St Marys Roman Catholic School
Glamis Street
Bognor Regis
PO21 1DJ

Please ask for: Mrs D Johnson
Email: daun.johnson@arun.gov.uk
Telephone: 01903 737762
Our Ref: BR/21/25/PL
Your Ref:
Date: 7th February 2025

Application for Planning Permission

Development: Extend the height of existing brick boundary wall by adding a 1.2m high green twin mesh fence, to sit above existing wall between the boundary of the school field and Hotham Park. This application is in CIL Zone 4 (Zero Rated) as other development.
Location: St Marys Roman Catholic School Glamis Street Bognor Regis PO21 1DJ

Location Plan

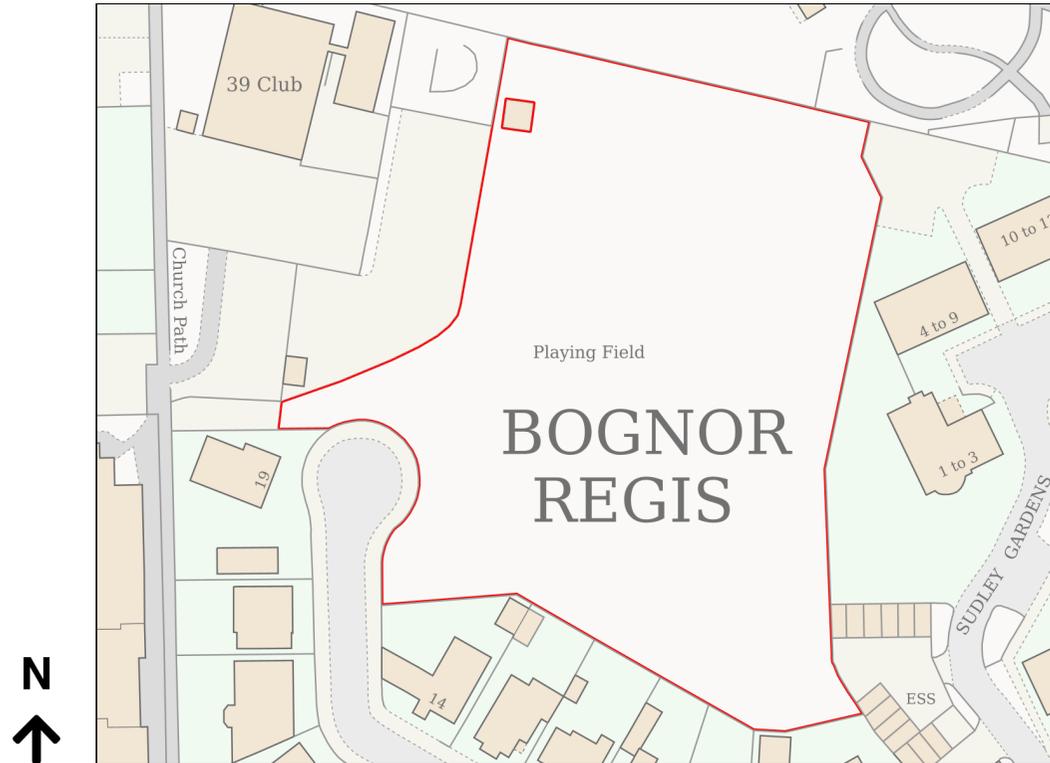
The location plan and block plan do not scale correctly. Please provide a block plan at 1:500 or 1:200 highlighting the proposed works.
